Letter No: B. 26530/96

Sub: MMDA - RPU - PP - Regularisation of deviated  
corner of AF-2A Commercial locality P.N. 35  
Royapettah High rd, R.S.N. 1100/11.35, 1101/1x2  
1102/1x3 b/b No 23 Mylapore ch. Remittance  
of charges - reg - reg  
Ref: PPA received in SBC n/e 1609/96 dt 31.10.96

Letter No. **B1/26530/96**

Sub: CMDA - APU - Planning Permission - Regu-  
larisation of deviated construction of  
Ground Floor + 2 floor commercial building  
at Plot No.35, Royapettah High Road in R.S.  
No.1100/11,35, 1101/1&2, 1102/1&3, Block  
No.25, Mylapore, Chennai - Remittance of  
balance amount of D.C. - Requested - Reg.

GROUND FLOOR PLAN

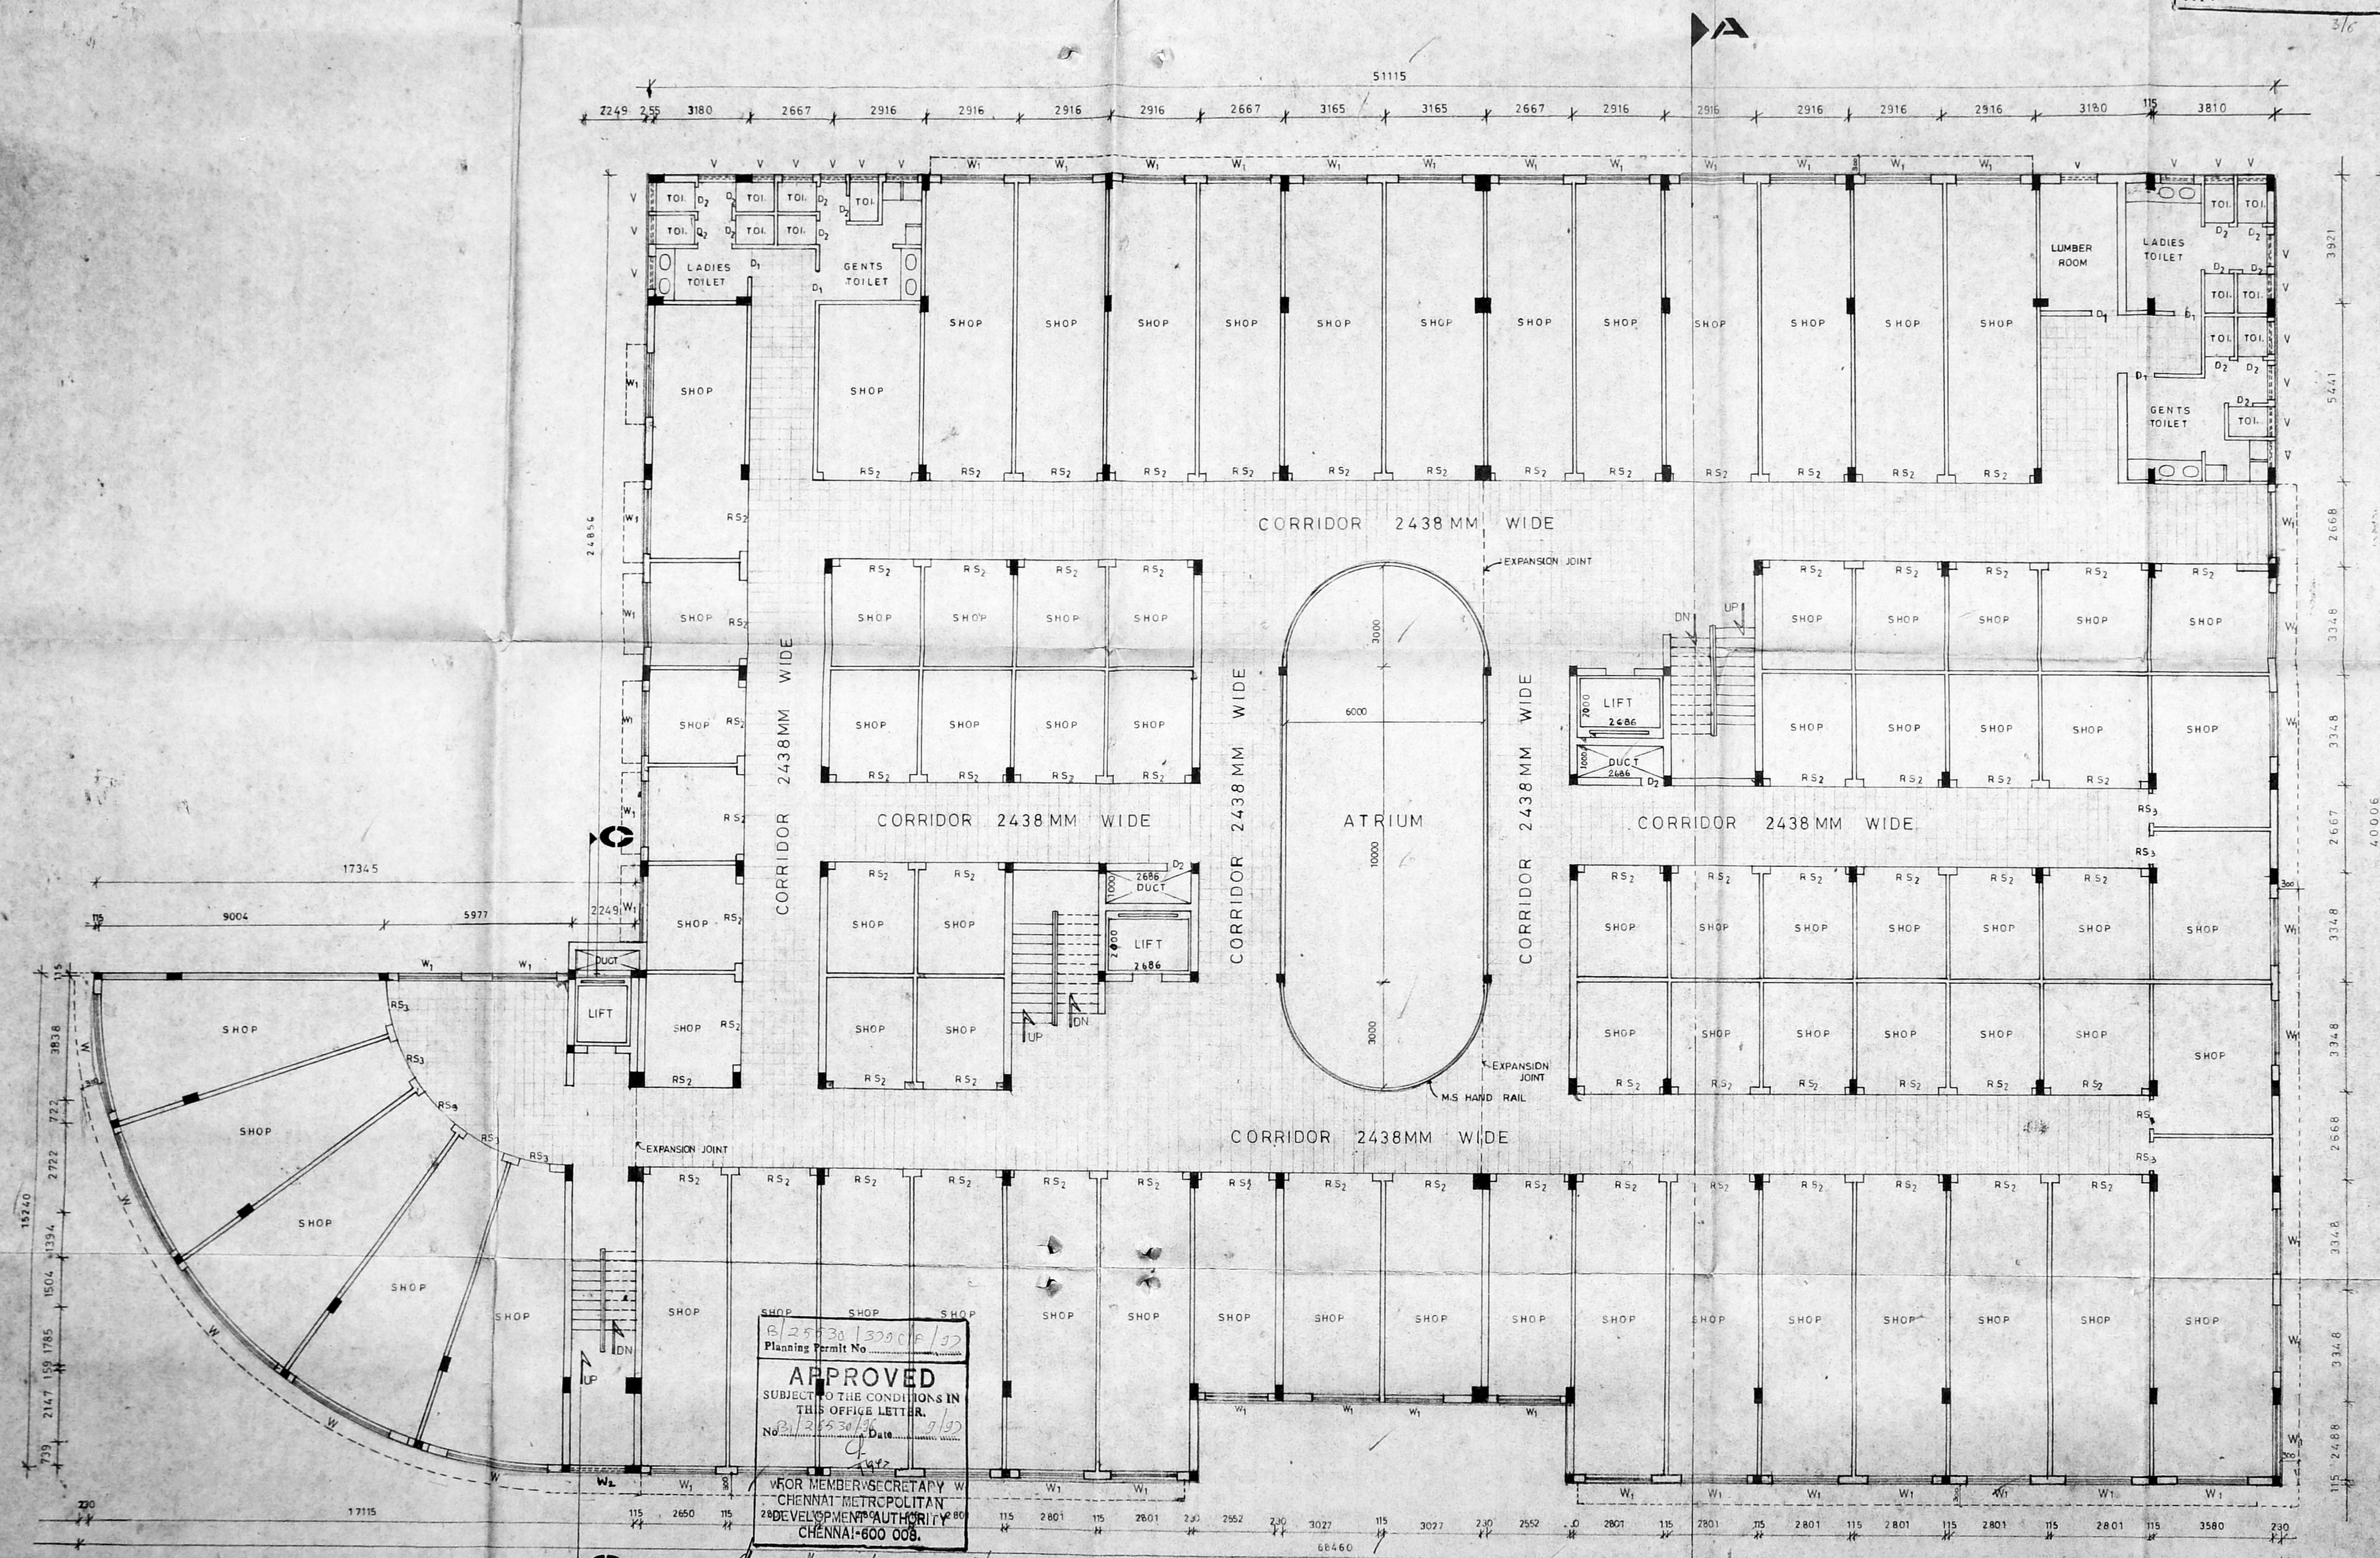
6. Furnish 5 sets of RP, <sup>showing</sup> 49 Parking lots and also satisfying the Turning radius requirements of DCR and further showing the plan tallying with the site conditions and elevation details.
